Department of Primary Industries

OUT15/36055

**Lucas Heights Resource Recovery Park Project (SSD_6835)
Response to exhibition of Environmental Impact Statement**

Lucas Heights Resource Recovery Park Project (SSD_6835) Response to exhibition of EIS Detailed comments - DPI Water

**Figure 3:** Garden Organics Facility

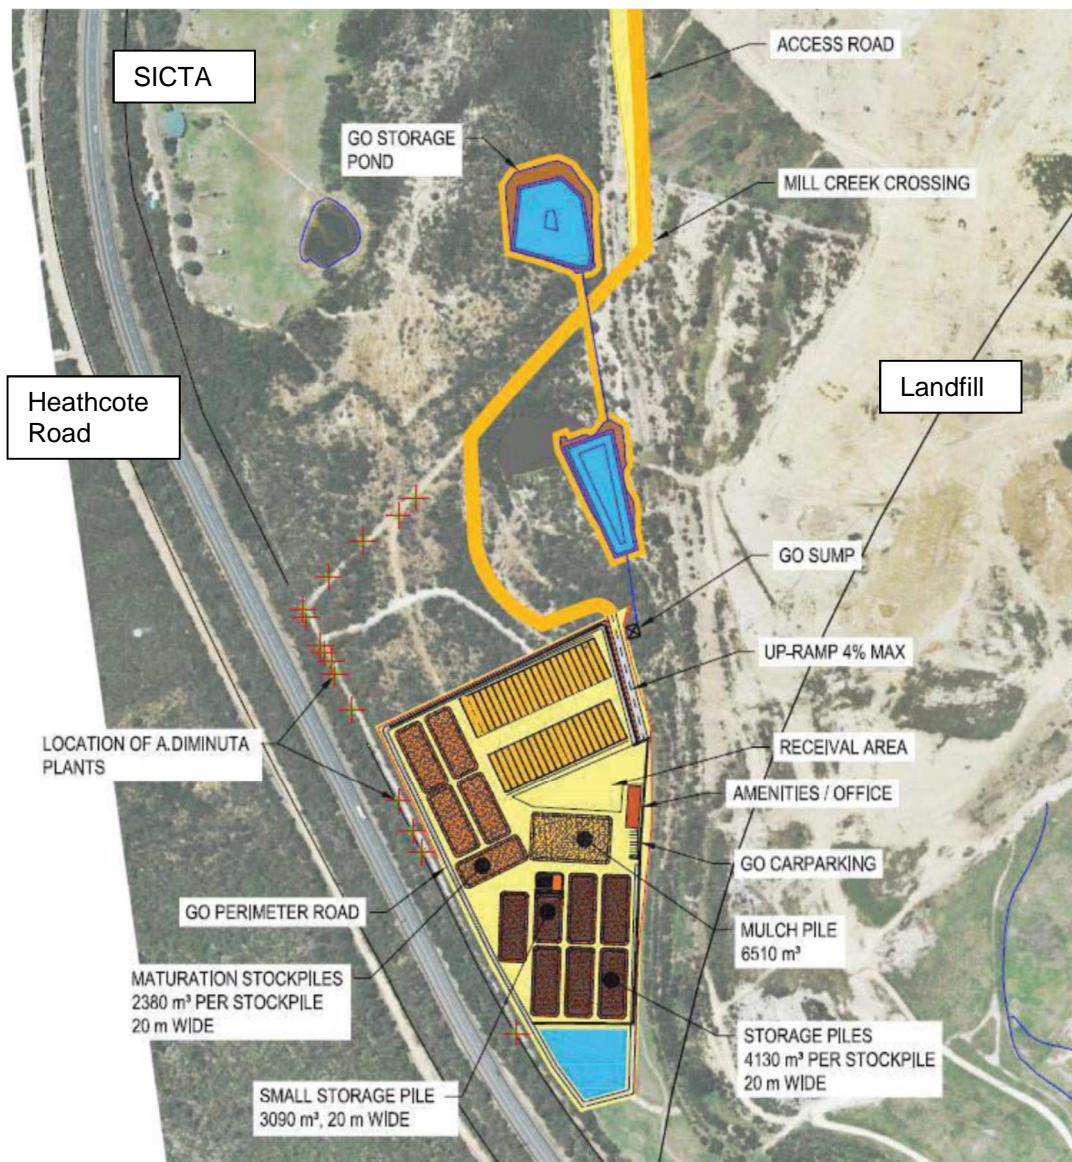
- Consideration is given to locating the proposed Garden Organics (GO) storage dam to the south of the GO facility on land that is already cleared of native vegetation rather than locating it adjacent to Mill Creek on land that is currently vegetated with native vegetation.

**Figure 4: Advanced Resource Recovery Technology Facility**

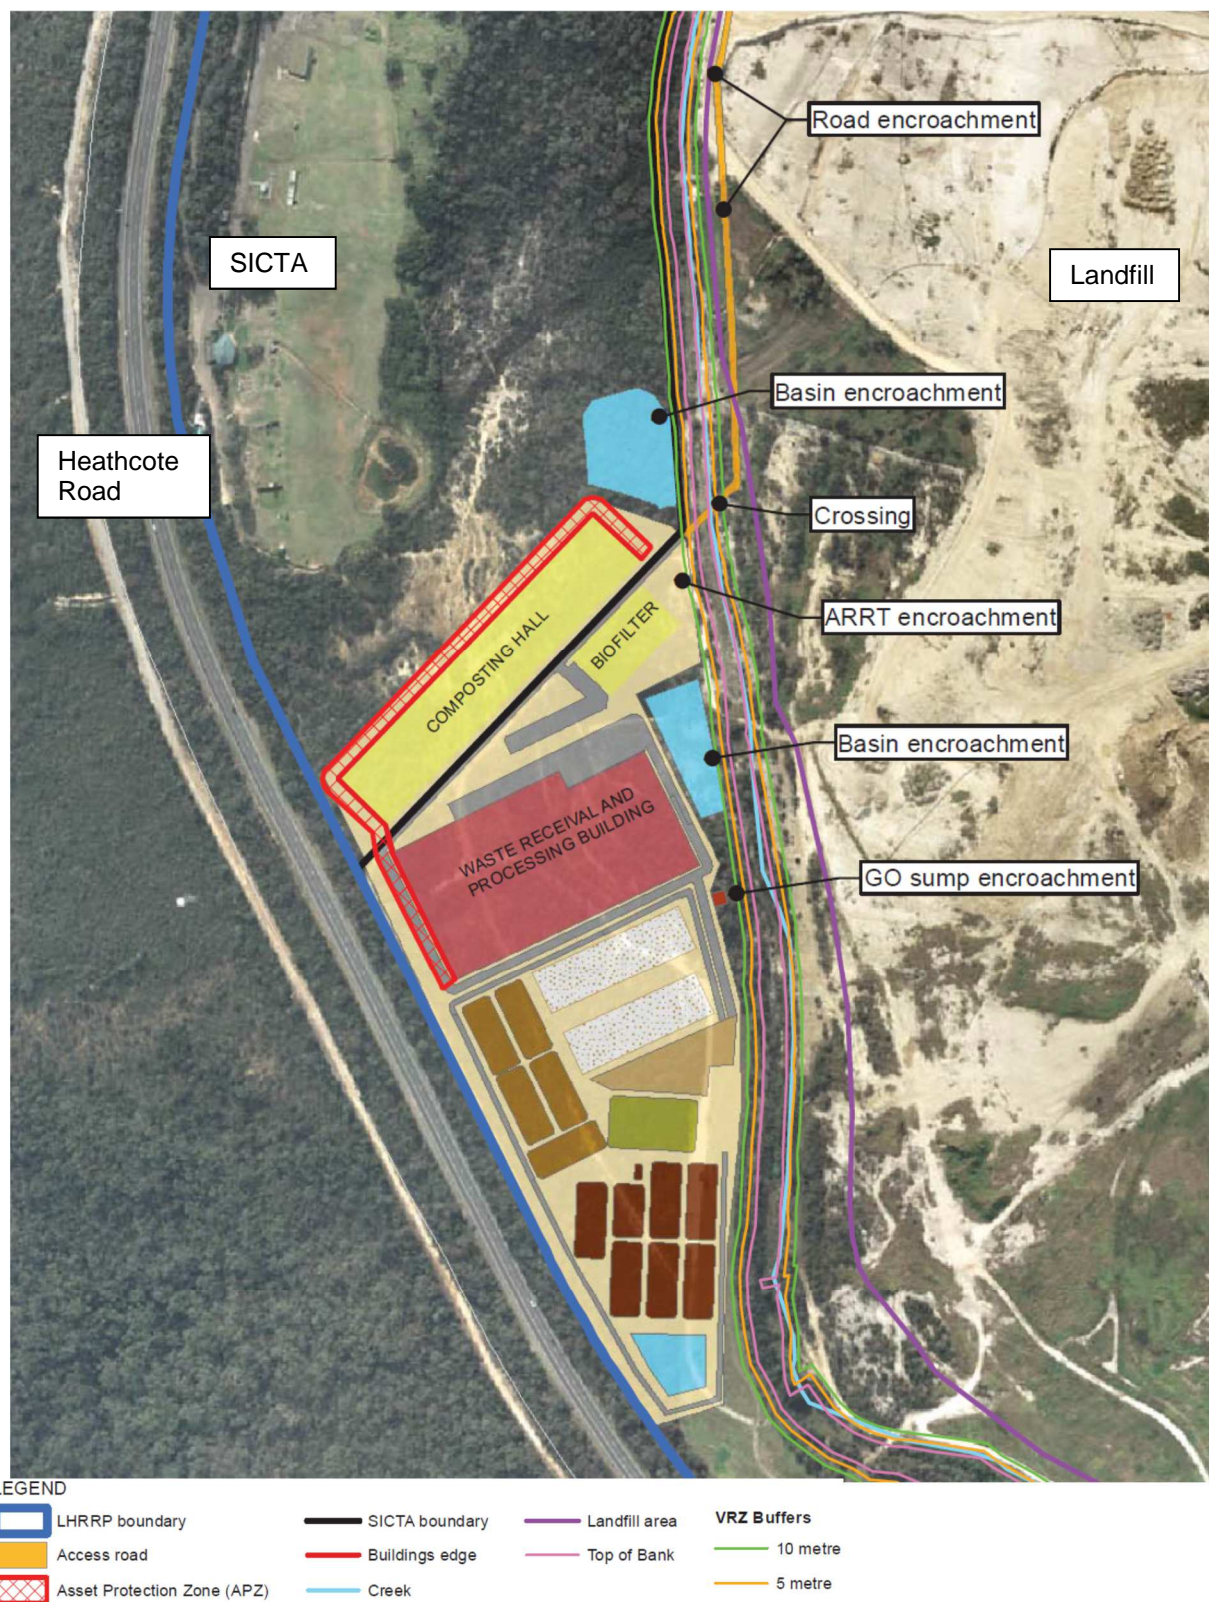
- The proposed sediment pond/detention pond which is proposed to be located north of the ARRT facility is located elsewhere on the site to avoid potential impacts on the Coastal Upland Swamp.
